From: Jeff Watson
Sent: Wednesday, December 30, 2015 9:47 AM
To: Chuck Cruse (cruseandassoc@kvalley.com); rossa@acarchitect.com
Subject: BL-15-00016 Anderson
Attachments: BL-15-00016 Anderson Map Air Photo Oblique Zoom.pdf; BL-15-00016 Anderson Map Air Photo Vertical Zoom.pdf; BL-15-00016 Anderson Site Plan.pdf

[BL-15-00016 Anderson](#)

Proposed

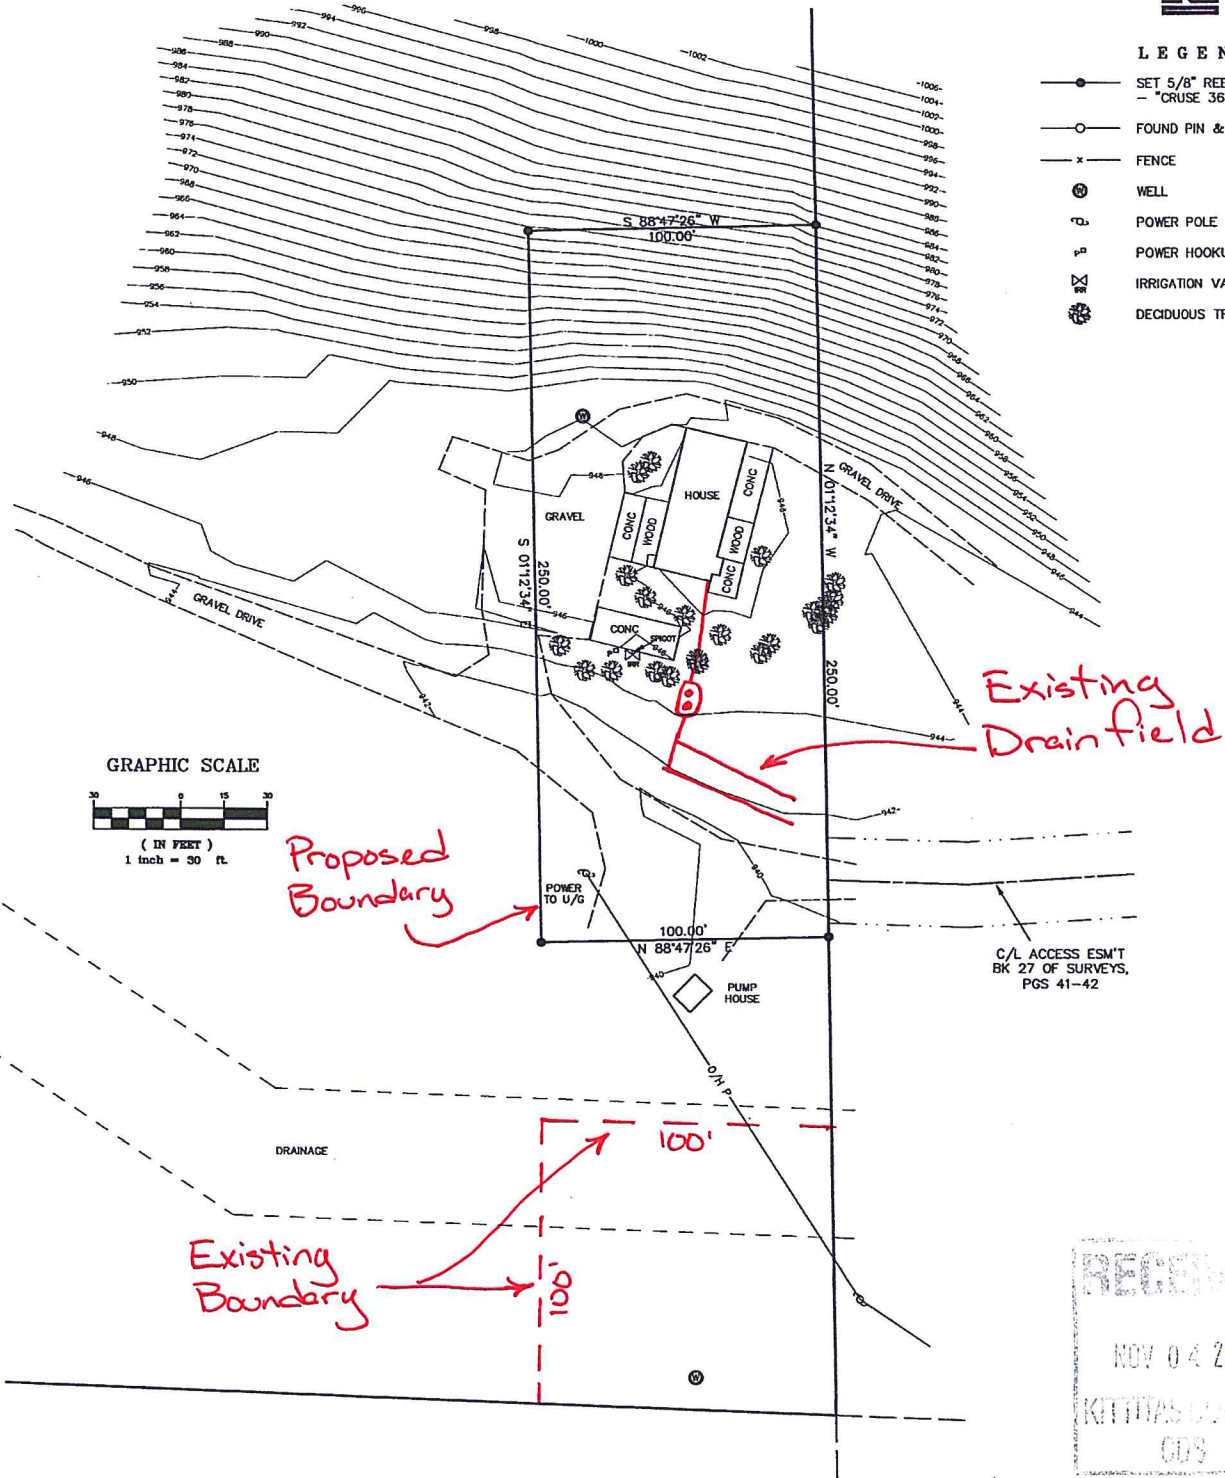
I have received comments from all required departments, reviewed the file in detail, and need clarification on one point. The site plan provided does not appear to portray the garage/storage structure west of the house. If in fact the structure still exists, it appears to me that proposed western property line may not provide for the ten foot rear property line setback required in the Forest and Range zone (it's hard for me to tell but it appears the proposed line may dissect the garage footprint). Even if the garage is entirely inside large parcel it is likely it will not meet the required 25 foot setback for a front property line in Forest and Range. Could you please clarify and/or provide a revised site plan depicting the location of the garage which indicates that all setbacks for the zoning will be respected.
